To:	DA Mattox
From:	Thomas Melville
Date:	March 27, 2018
Subject:	SAFEbuilt Permit Review – Design Team Comment Response

The purpose of the memorandum is to capture and provide response to SAFEbuilt Permit Drawing Review Comments for East Tower Expansion as received on March 23, 2018. Drawings are in the processes of being revised and are to be issued as Addendum No. 2 to direct the CM for revisions. Subsequent to this issuance, a full permit set will be issued to SAFEbuilt.

MMC EAST TOWER – BUILDING REVIEW

Drawing file: 04 - Architectural / A32-01 EXTERIOR SECTION DETAILS - TYPICAL.pdf

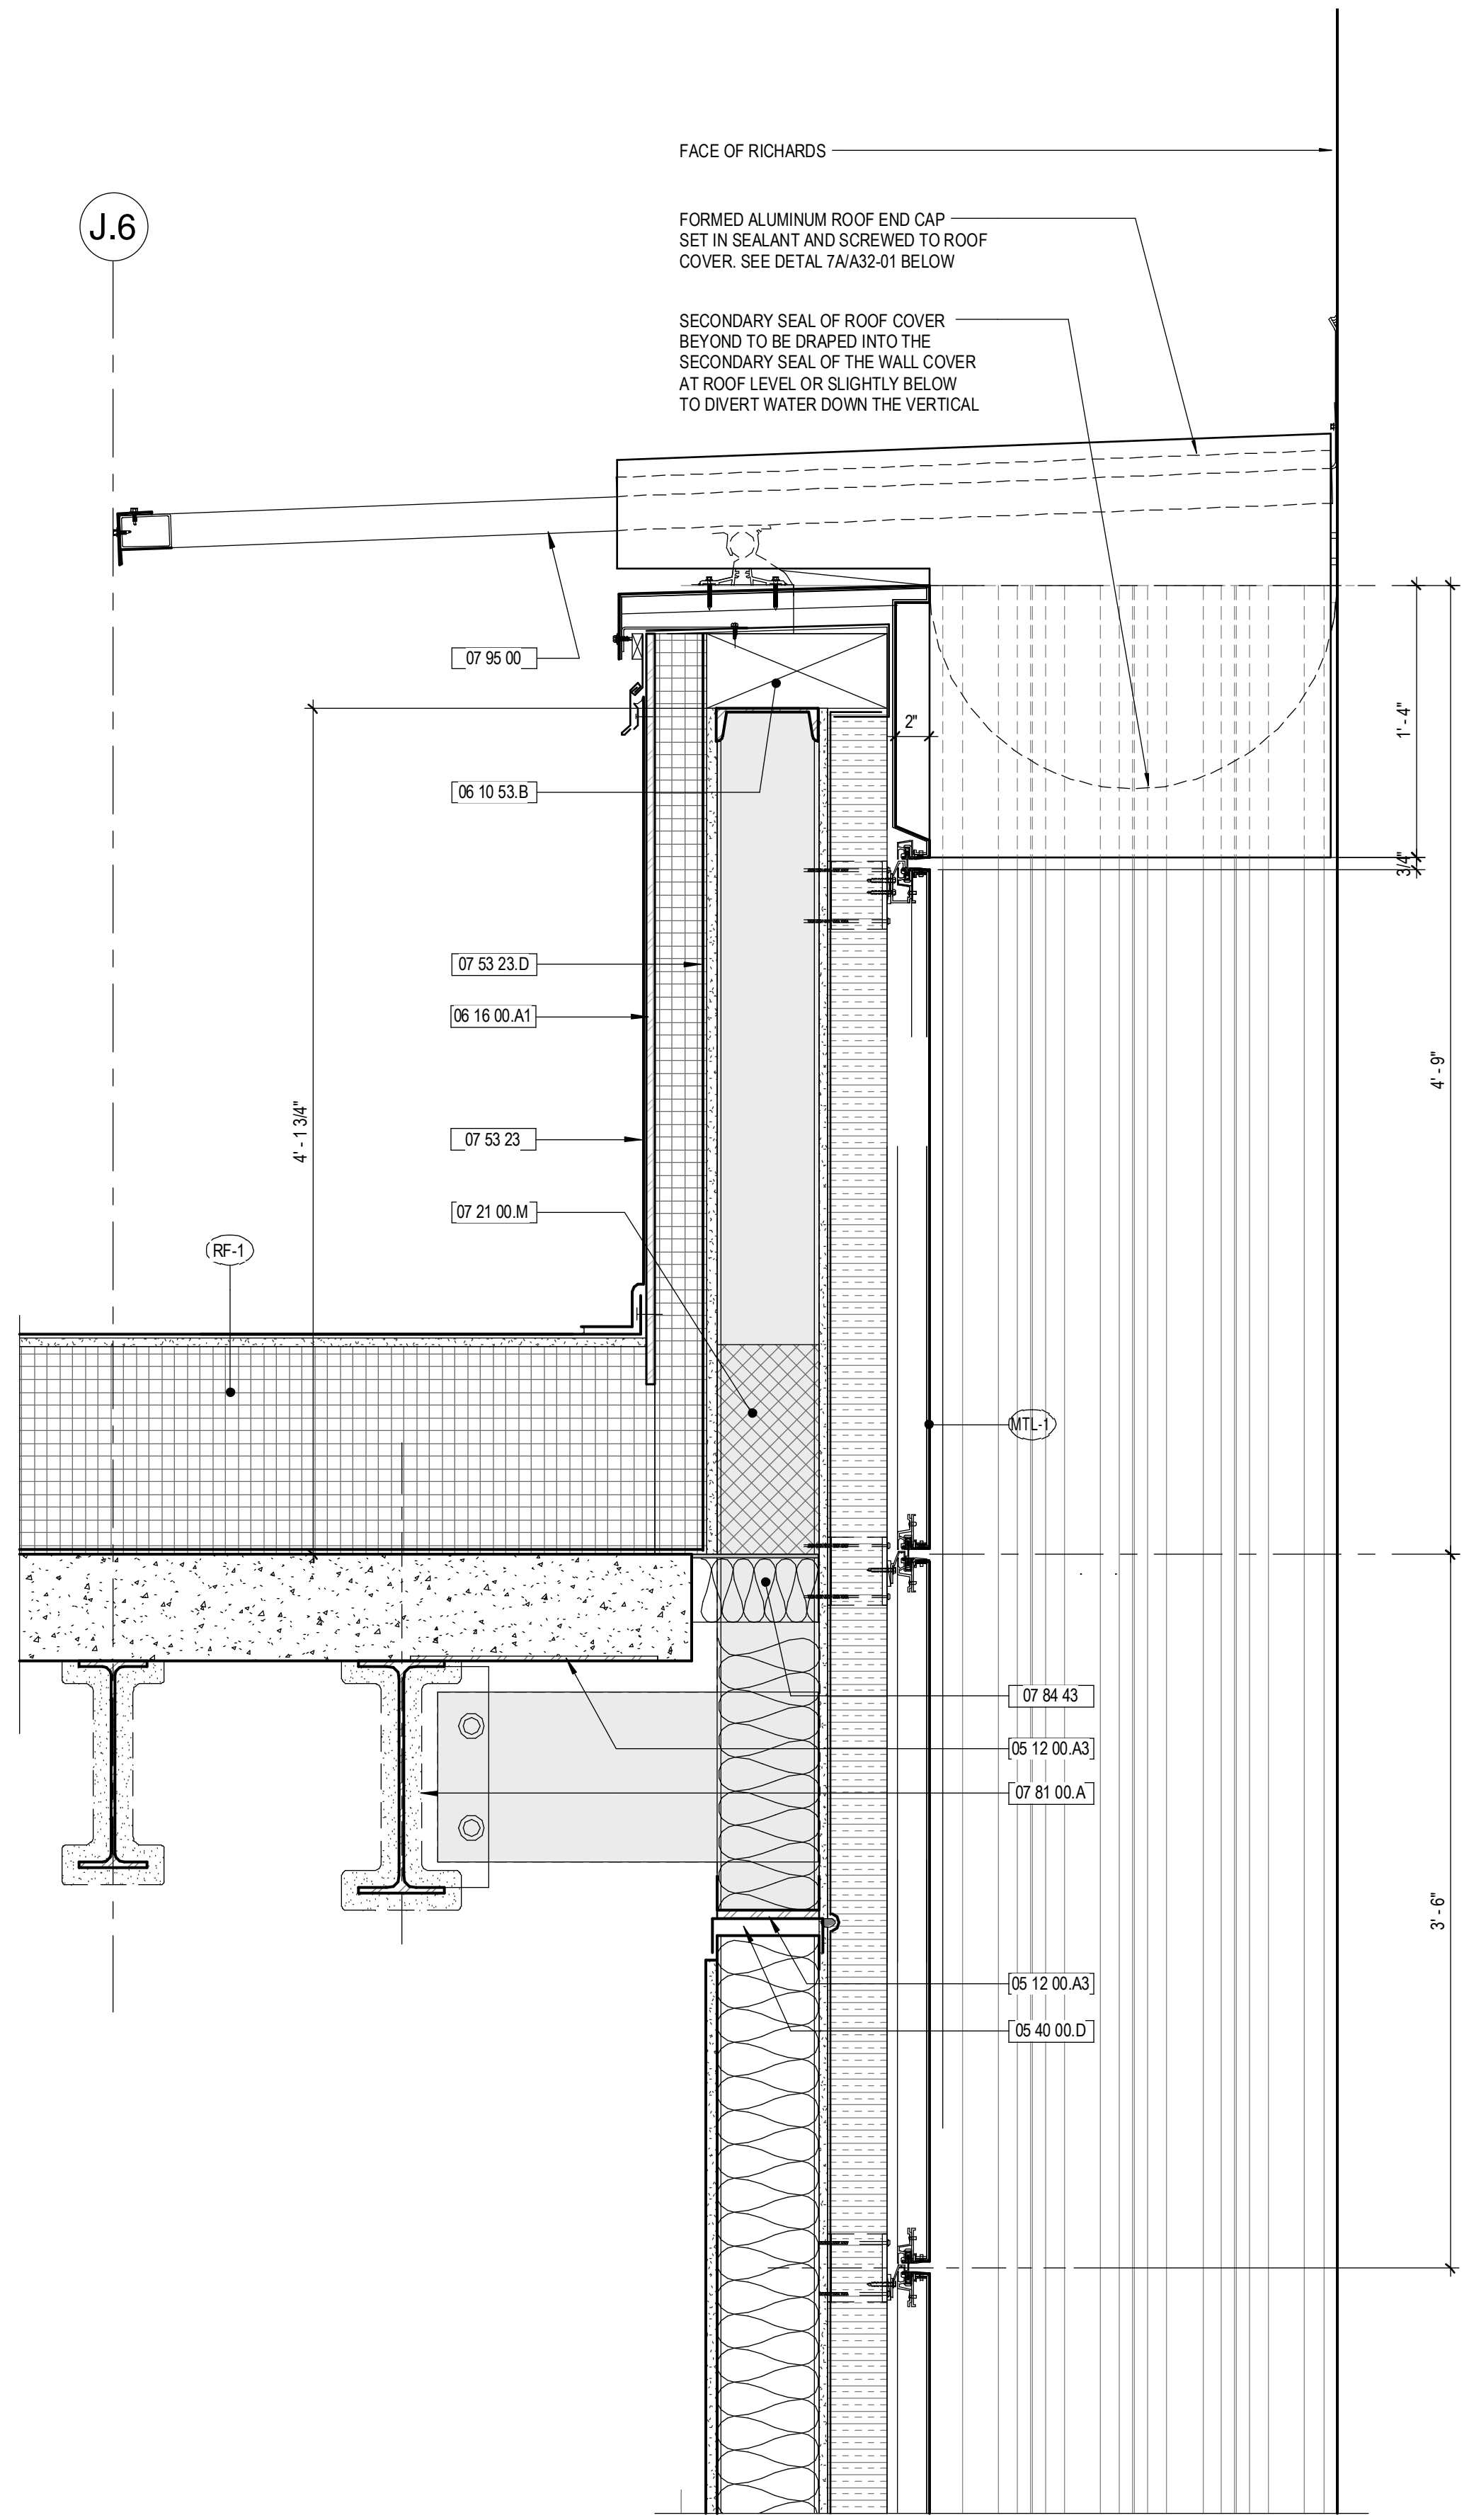
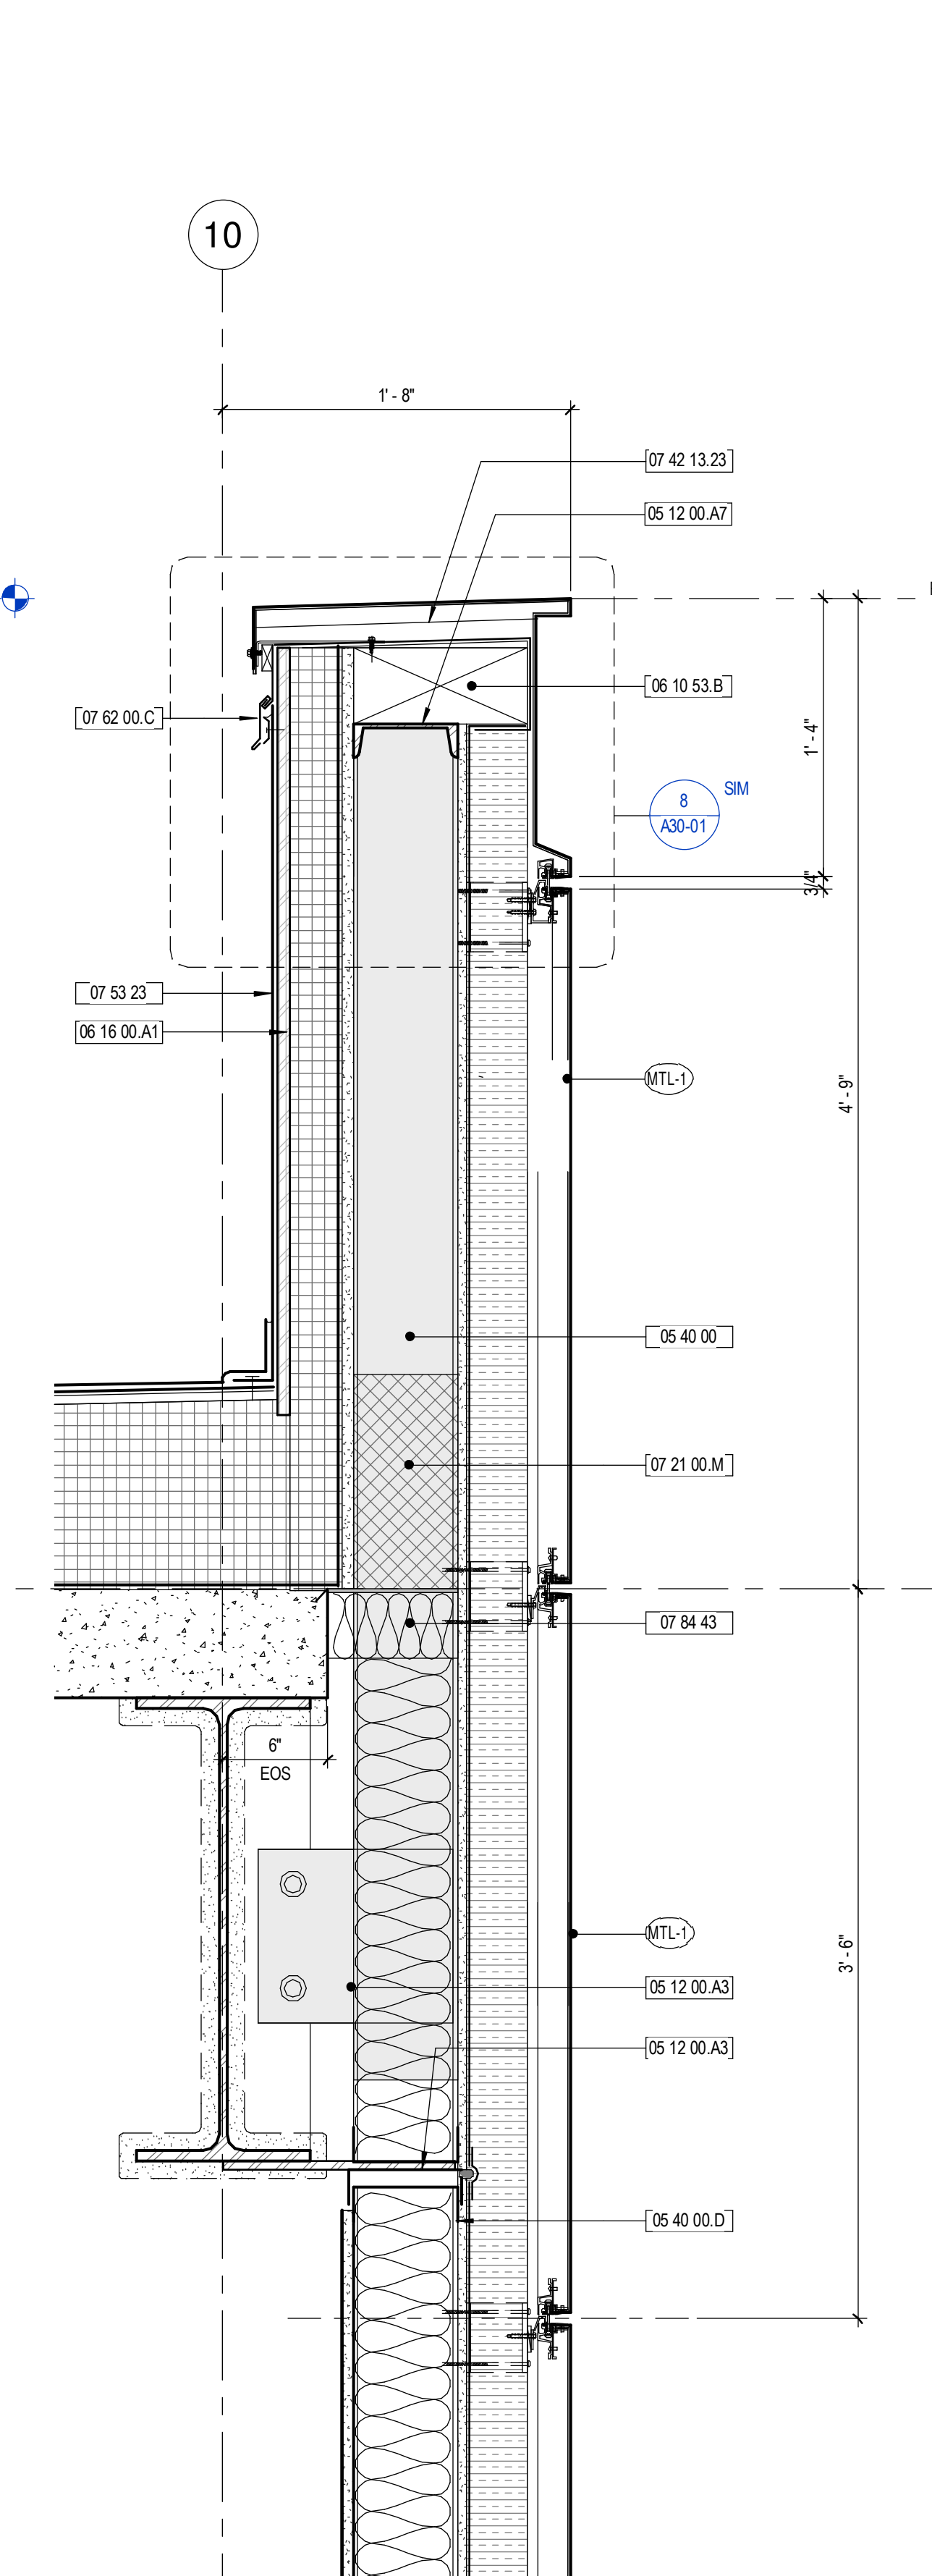
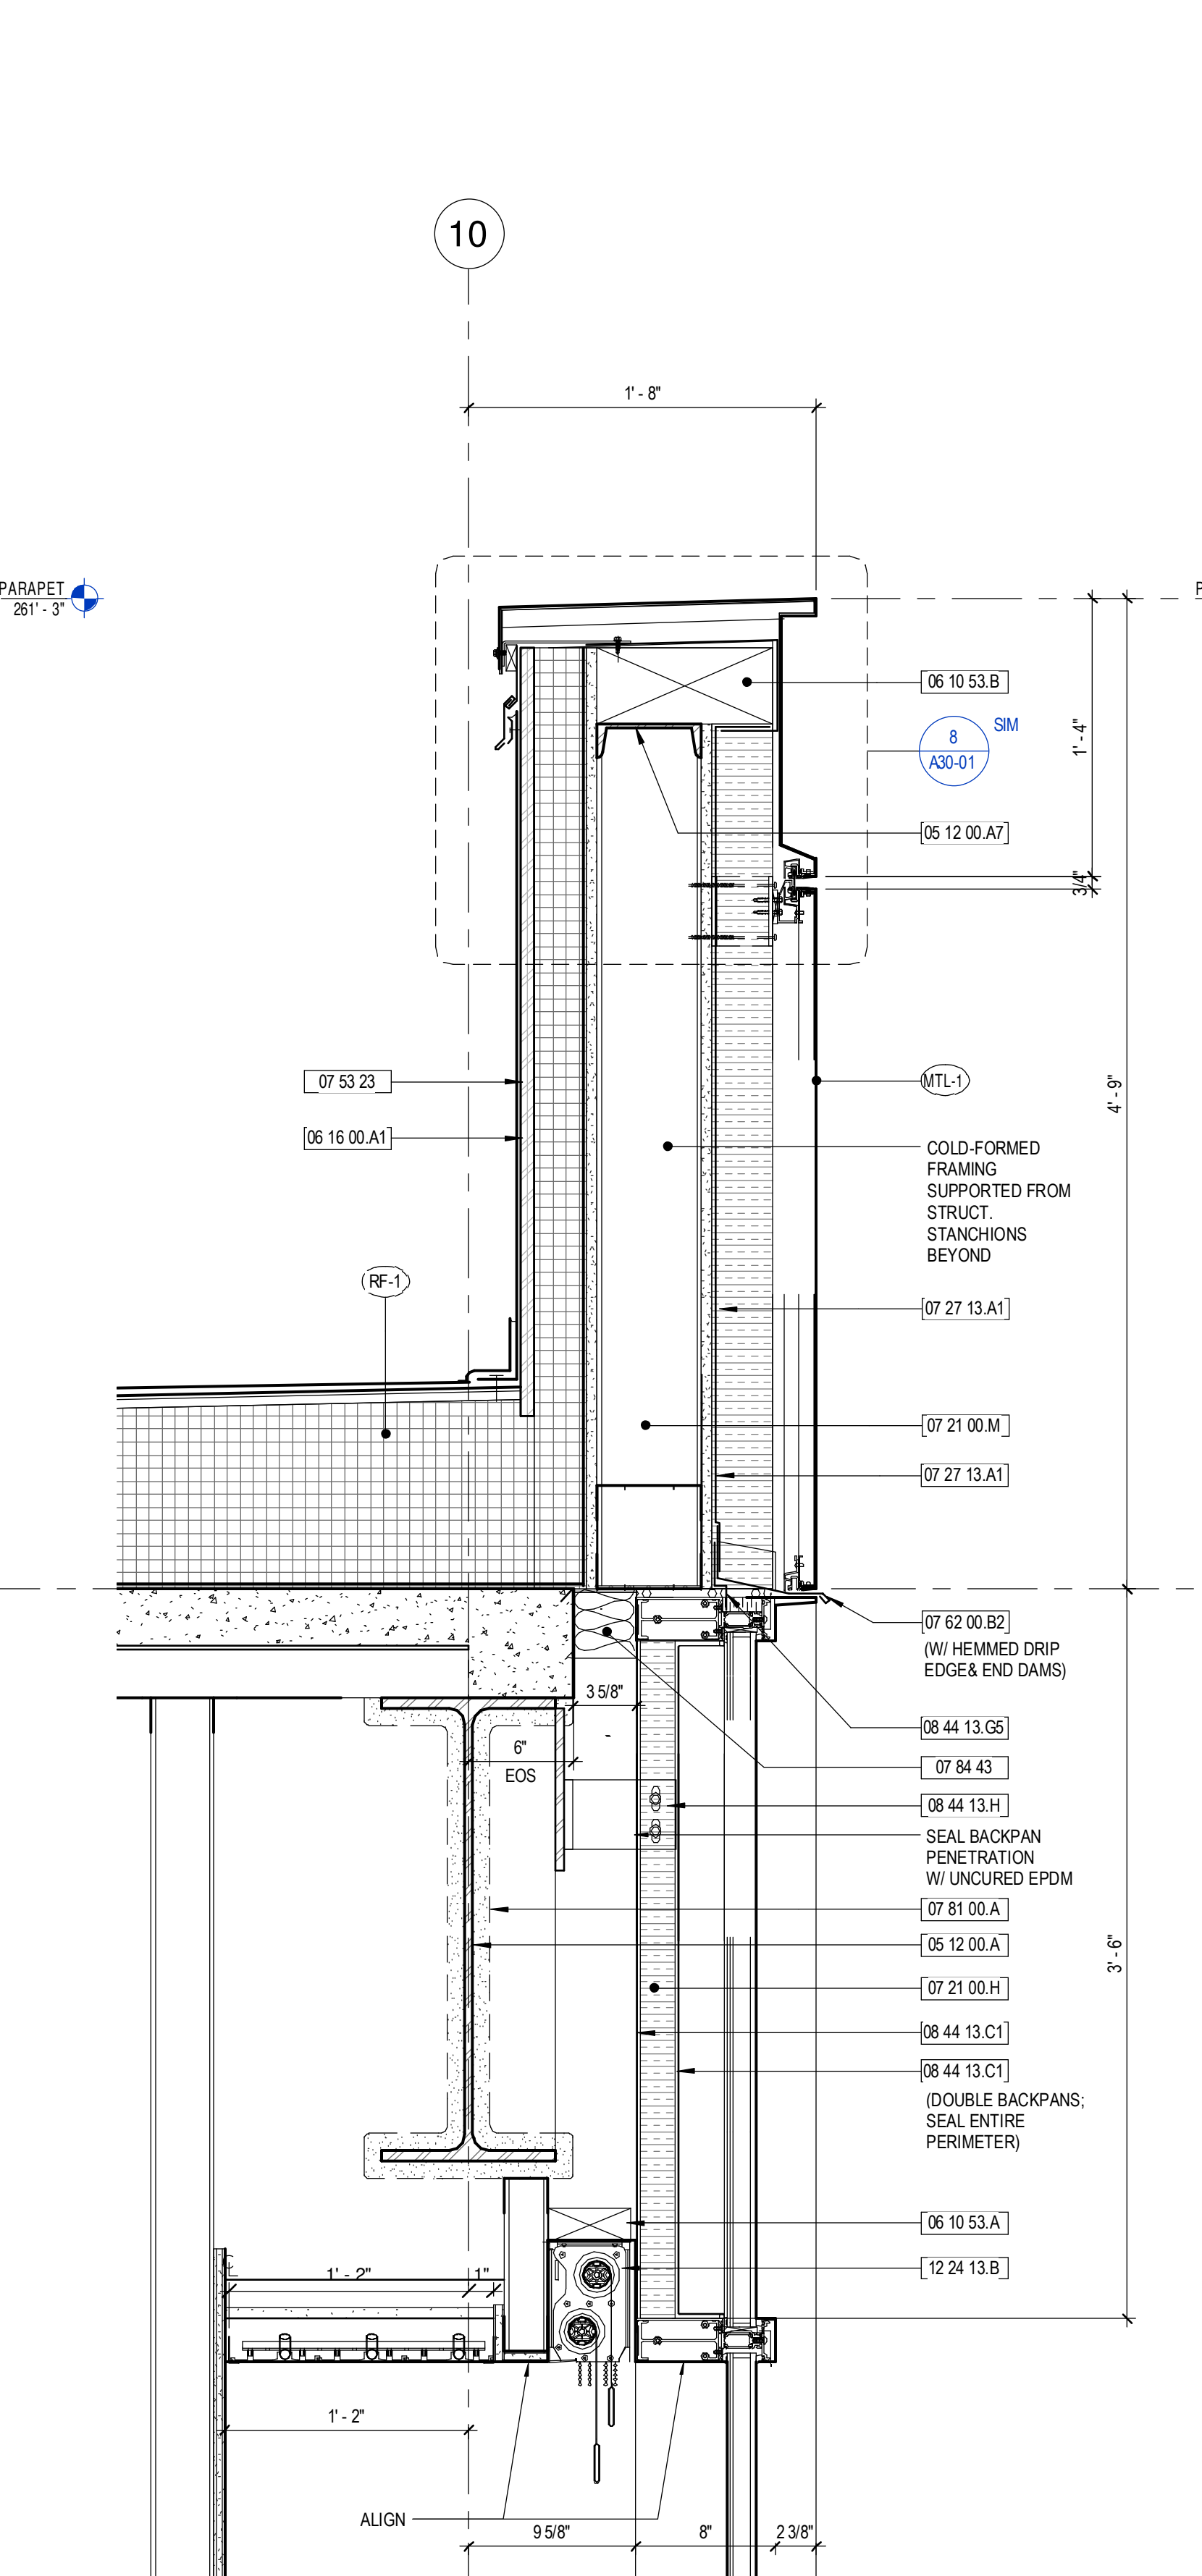
Provide the required fire-resistance ratings for the primary structural frame. A project code summary / analysis is not provided and the various details that show protected primary steel members (exterior section details on sheet A32-01 for example) note the protective material but do not provide a thickness or hour rating.

Exterior section details (sheet A32-04, etc.) specify pressure-treated wood blocking which is not included on the list of permitted combustible materials in Type 1 construction per IBC 603.1.

Fire resistive ratings for primary structural frame provided in Code Report distributed 3/16/2018.

Pressure-treated blocking will be replaced with fire-retardant-treated blocking. This revision will be indicated in Addendum No.2. IBC 603.1 allows fire-retardant-treated wood in non-bearing exterior wall where fire-resistance-rated construction is not required. Refer to Table 602 discussion in Code Report.
